Subject: RE: Planning Consultation on: CM/48/21/RES

Application No: CM/48/21/RES

Site Address: Land to the West of Church Lane South of Horsemere Green Lane Climping

Planning Reference: CM/48/21/RES – Outline Conditions - Planning Conditions 9, 10 and 11

Drawing No.	Rev.
D1886-PL105	E

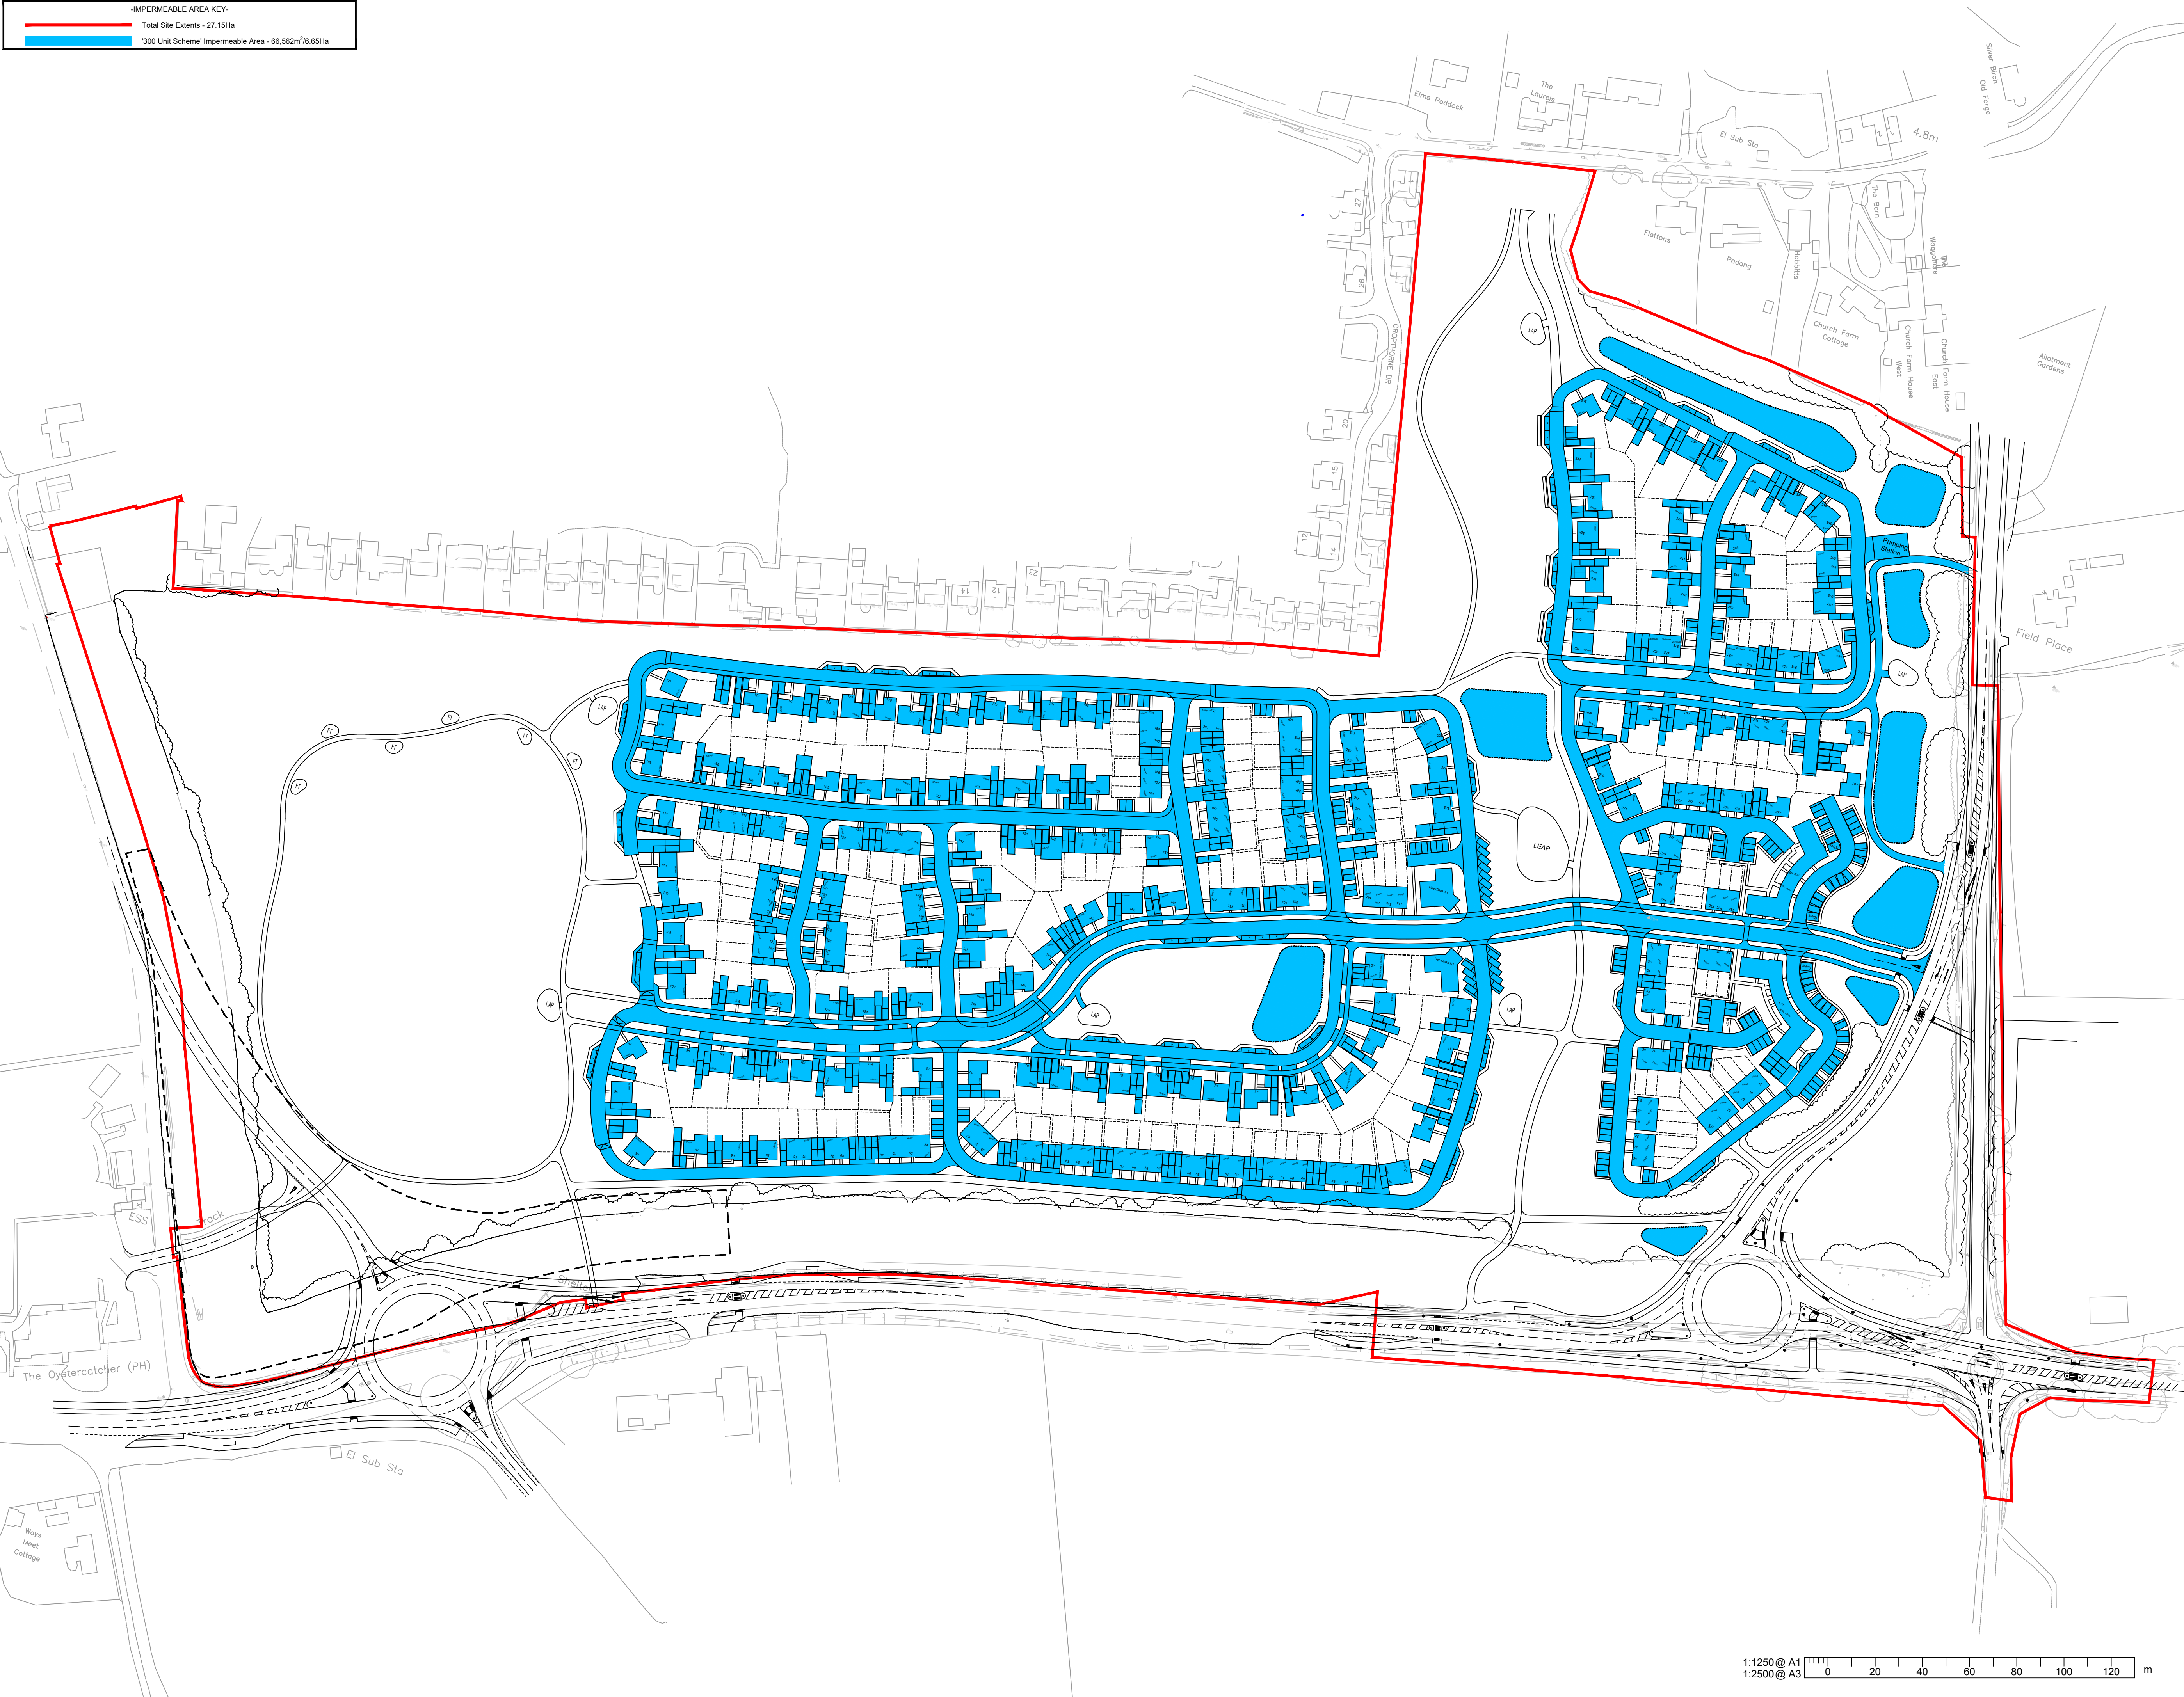
3	Please provide further information and commentary for the catchment which currently drains to the proposed point of discharge together with evidence that the receiving network has capacity to receive additional flows. This connection to the water course also serves the highway drainage for a large section of the A259 and Church Lane. An assessment is needed that the connecting pipe work has capacity to take the additional flow rate out falling from the site without causing a flood risk. The additional flow created by the highway work (roundabout will need to be considered in this assessment as they will ultimately flow through the connection to the watercourse.	24/10/2022

Drawing Status	PLANNING		
Client	Vivid and Climping Homes		
Project	Land adjacent to Church Lane, Climping, West Sussex		
Drawing Title	Proposed Drainage Sheet 2 of 4		
Scale	1:500	Date	Aug '21
		Drawn By	SPB
		Checked By	MJA
Drawing No.	D1886-002		
		Rev.	B

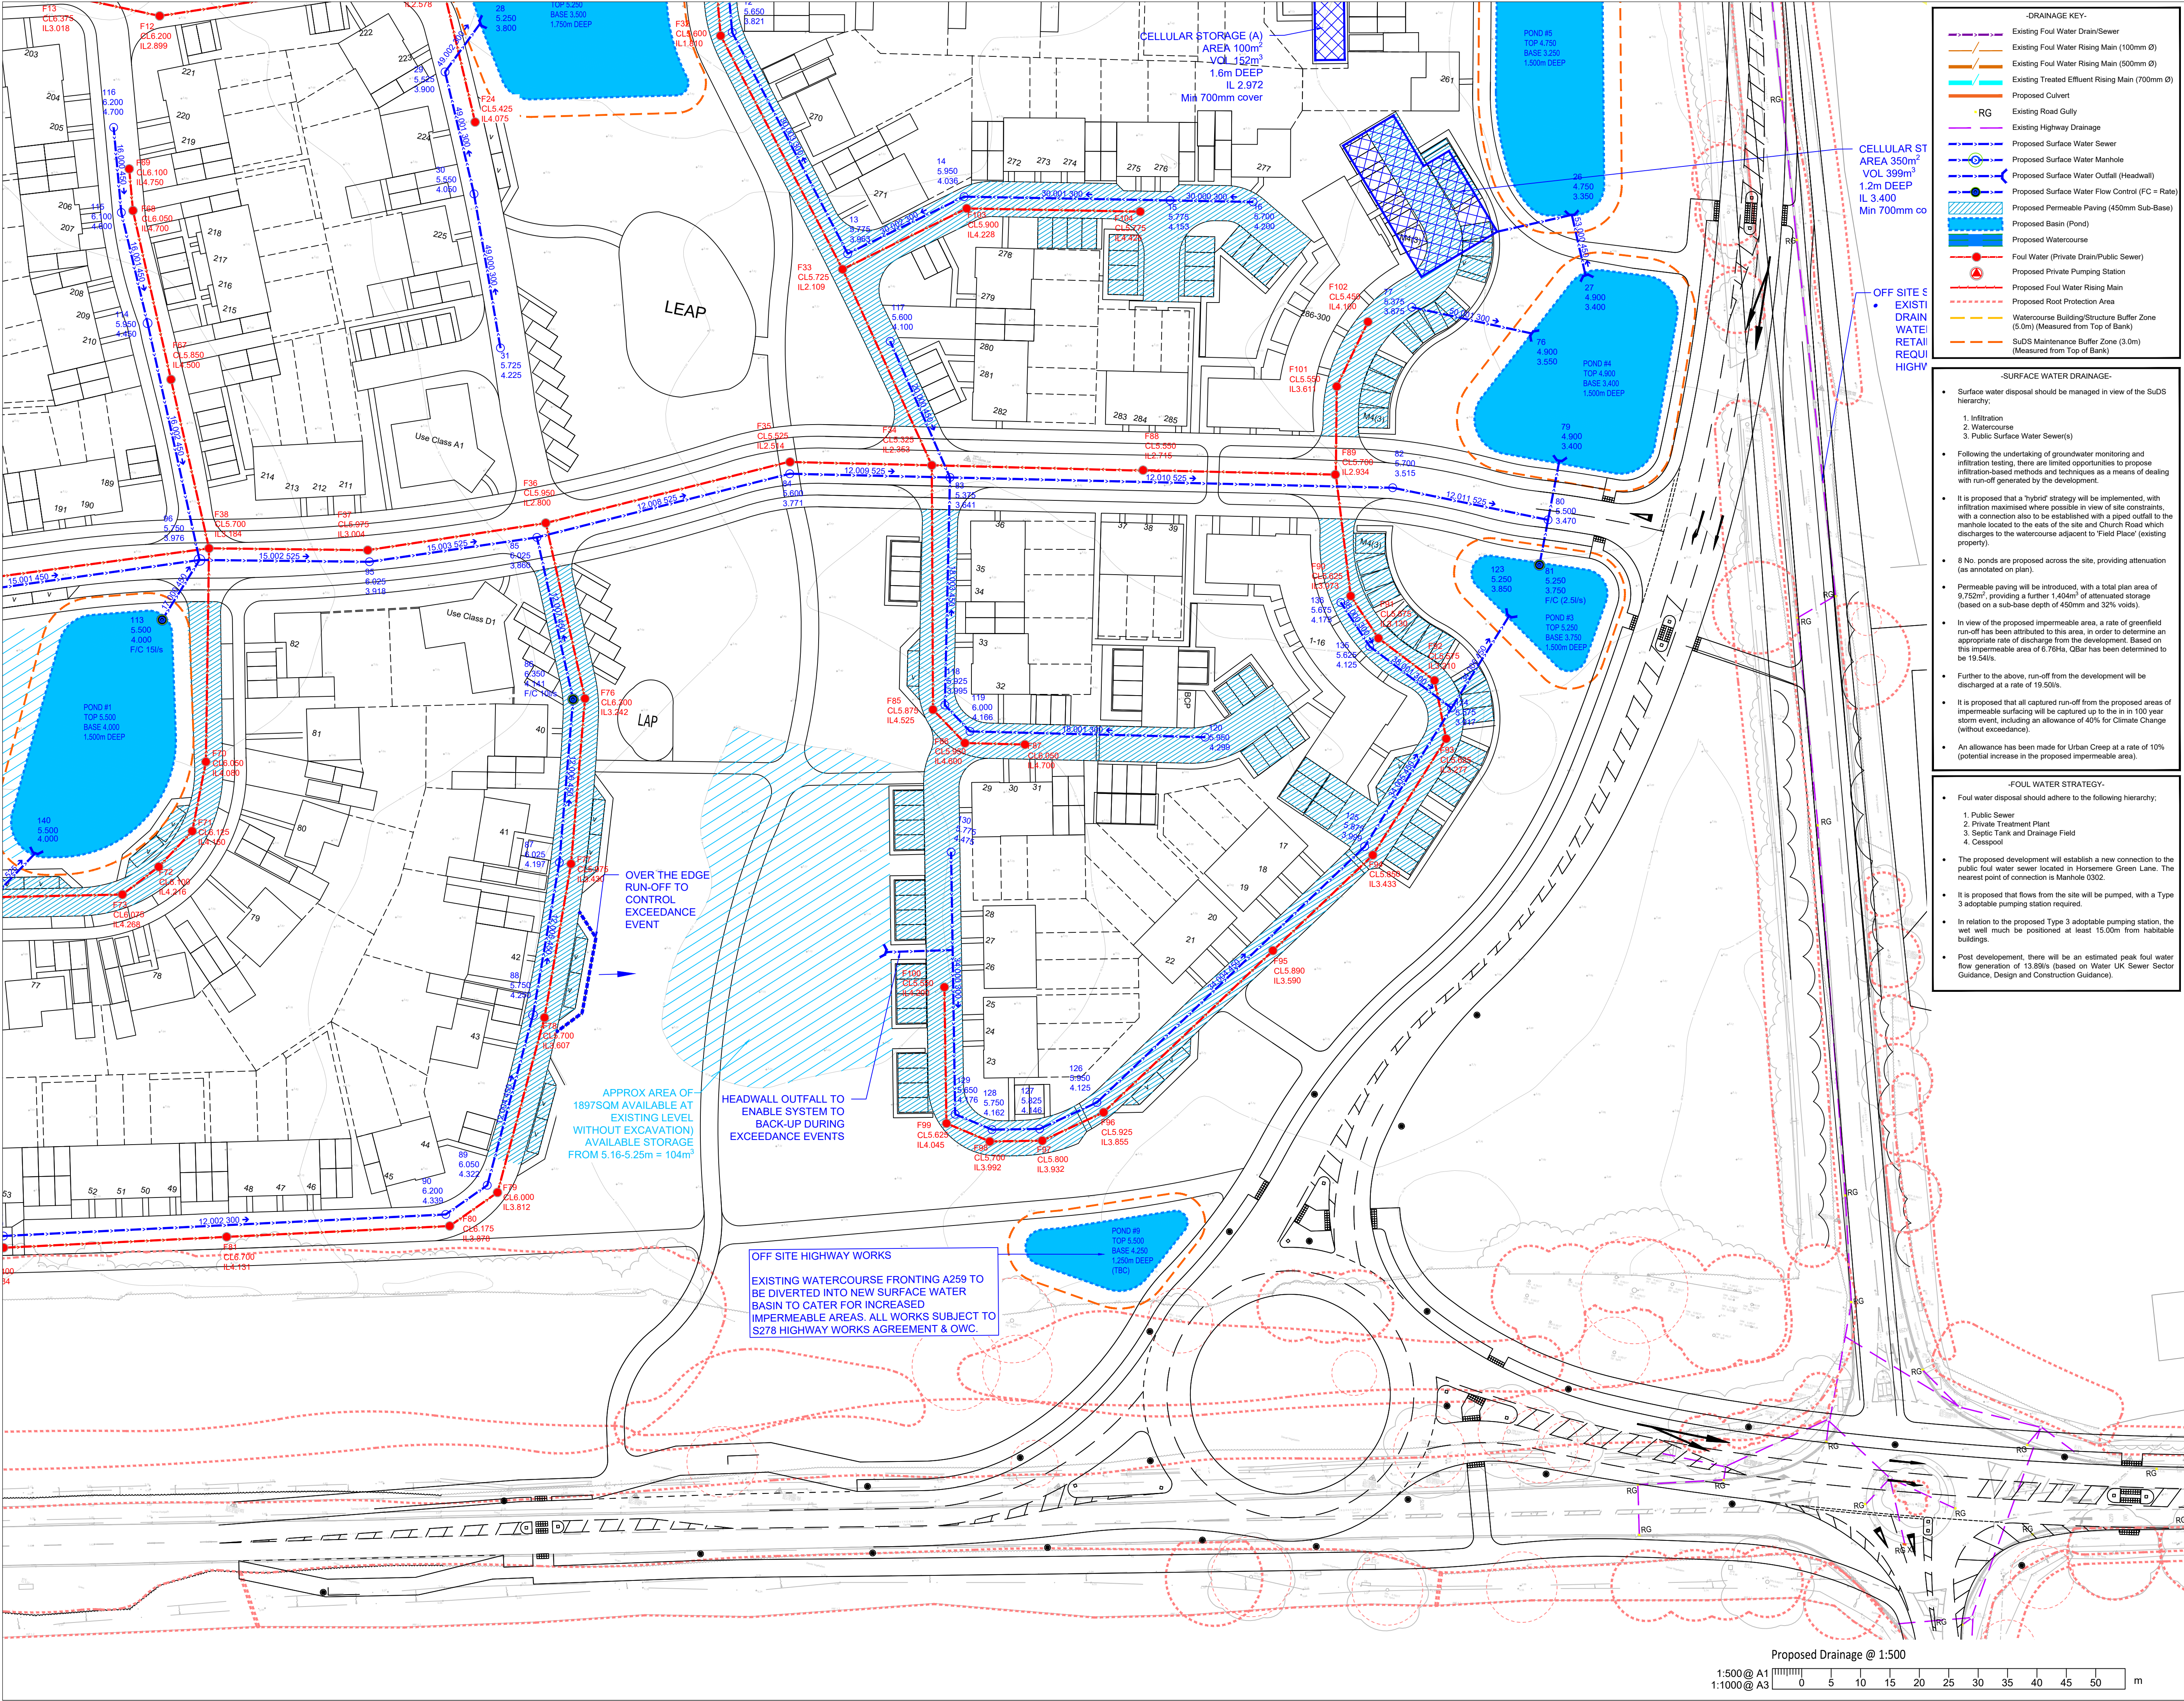
Some water levels in the flooded nodes are below the cover levels shown on the plan and may not flood should the model and the plan correspond. After some further investigation the node numbers and pipe number also do not correspond with the plan. For example, pipe 22.000 links nodes 141 and 140 however there is no pipe 22.000 shown on the plan. Please investigate. The plan should accurately show all pipe numbers and node numbers that correspond to the calculation. Together with pipe lengths and gradients shown as well. Also, the exceedance routes at the south of the site I.E near node 92 flow into and area where levels cannot be assessed. Please provide information on these areas.									
16	It should also be noted that as some of the exceedance events are for the shorter storm durations it is likely that upsizing pipes may combat the flood occurrences and keep the water below ground for all events, please can this be explored. The exceedance flow paths shown do not align with the contour perpendicularly. Also, no kerbing details are shown on the plans or have been provided. Please update the fall arrows and a plan confirming where full height and drop kerbs are proposed so that an assessment of the exceedance areas and routes can be made.

17	Further details of the permeable paving storage blankets is required. As above the nodes within the calculations and the plan do not correspond. Also please provide a plan showing the dimensions of these areas together with the area of each system. Also, it is noted the slope for each of these systems has been entered at 1:100 within the calculation however the gradients of some of the paving in these areas is much steeper. Are these blankets intended to be used for storage or just water quality improvements?									
18	There are a number of Orifice flow controls included within the model. These cannot be identified on the plan. Please confirm their location and function within the design.									
19	The drain down time within the calculation is set to 240min. therefore no half drain times for the storage structures have been calculated. Please increase this to over 24hrs and include half drain times for each system.
